From: Simon Davis
Sent: 20 April 2018 16:37
To: 'Paul Spratt'
Subject: P/1/18/DOC

I've been looking at these condition decisions this afternoon and have questions re conditions 14 & 26.

drawing title	Landscape General Arrangement (East)				
drawing no.	1896-TF-00-00-DR-L-1002				P03
scale	1:250 @ A1	date	28.09.17	drawn by	AC
				checked by	AC

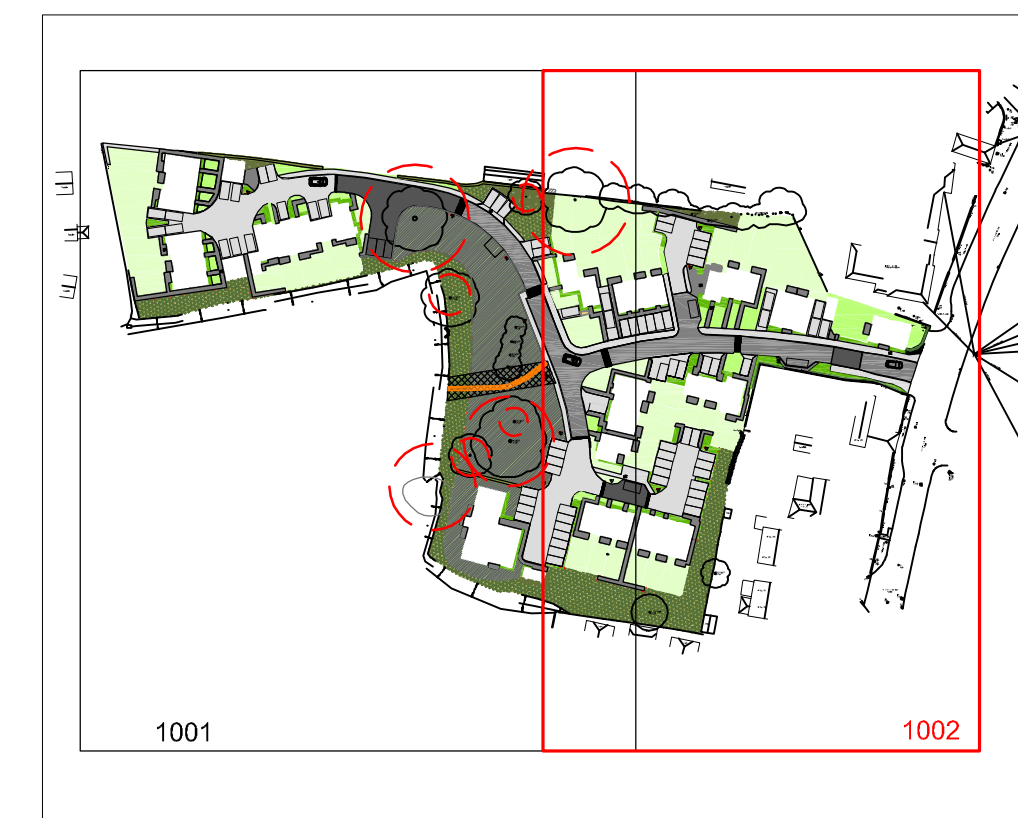
26 -- The details for this are the bollard lighting as per the street lighting condition. This is fine but can you confirm that no external lighting will be attached to the houses. If you are proposing external lights to the houses, then it is these details, we need to approve.
